FAO Ellie Thornhill  
Kirklees Council  
Planning Services  
PO Box 1720  
Huddersfield  
HD1 9EL

**Date:** 27 February 2024  
**Our ref:** 65150/01/JG/JSt/29894096v2  
**Your ref:** 2023/48/93350

## 2023/48/93350 - Former Deighton Centre. Consultee Comments

Table 2 : Response to KC Landscaping Comments

BOUNDARY TREATMENTS

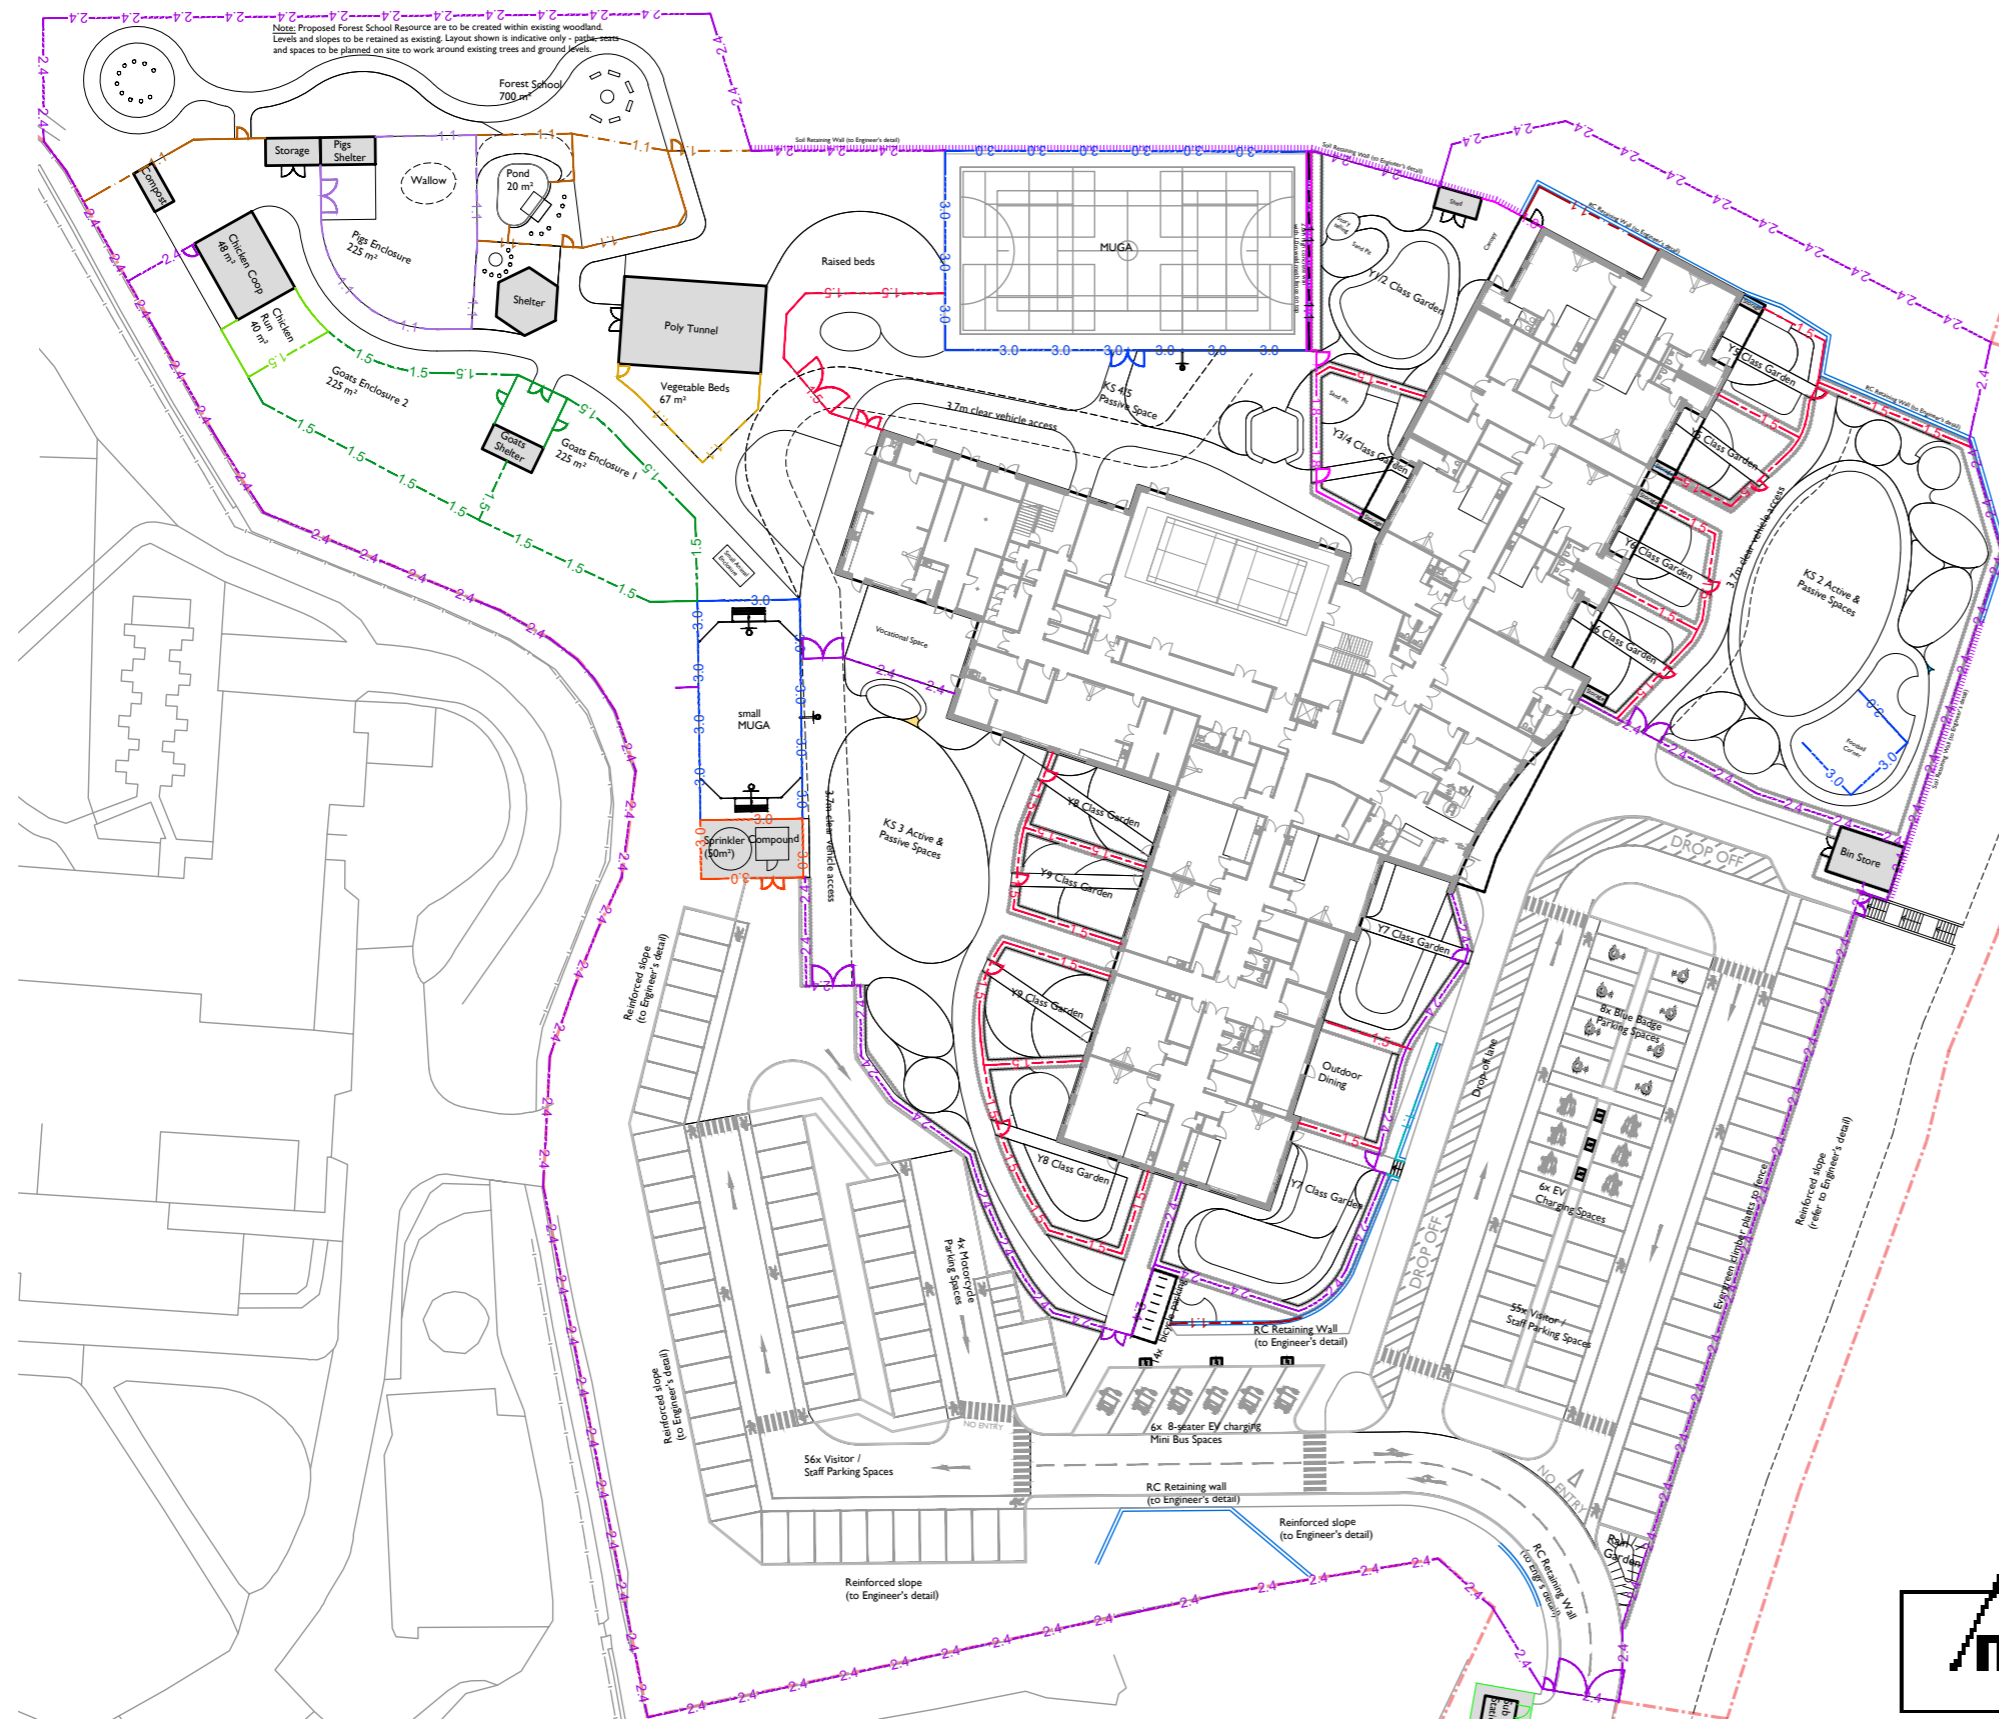
<i>MUGA fencing shown is not heavy duty - check if this is the appropriate standard for the school.</i>	The proposed MUGA fencing has been revised to a heavy duty specification and shown on the Boundary Treatment Plan [L-2352-GAP-1100 Rev. 14].
<b>Existing Trees:</b> <i>Unclear how the retaining walls, paths and especially level changes work in relation to root protection zones of the adjacent trees especially along the northern boundary. It looks potentially problematic in multiple locations. Arb officer to advise.</i>	KC Trees confirmed that the proposal is acceptable from a tree perspective.[11.12.2023]
<b>Canopy extents:</b> <i>The yr 1 – 2 class garden design is not developed and there are some anomalies with the canopy as shown. Clarity required.</i>	The year 1 – 2 class garden design has been revised. The plan has been revised to show the canopy. [L-2352-GAP-1000 Rev. 37].
<b>Active/passive areas</b> <i>There is no indication that the equipment described alongside other activities described fits in the space. A detailed layout including equipment and fall zones etc with a commitment to a quality level needs to be supplied.</i>	Indicative playground equipment and fall zones are now shown. This provides adequate space for the proposed activities. [L-2352-GAP-1000 Rev. 37].  The detailed layout of play equipment can be appropriately conditioned if necessary.

The updated fence offset is shown on revised boundary treatment Plan L-2352-GAP-1100 Rev. 14 and Cross Section (added to the proposed sections L-2352-SEC-3100 Rev. 14).
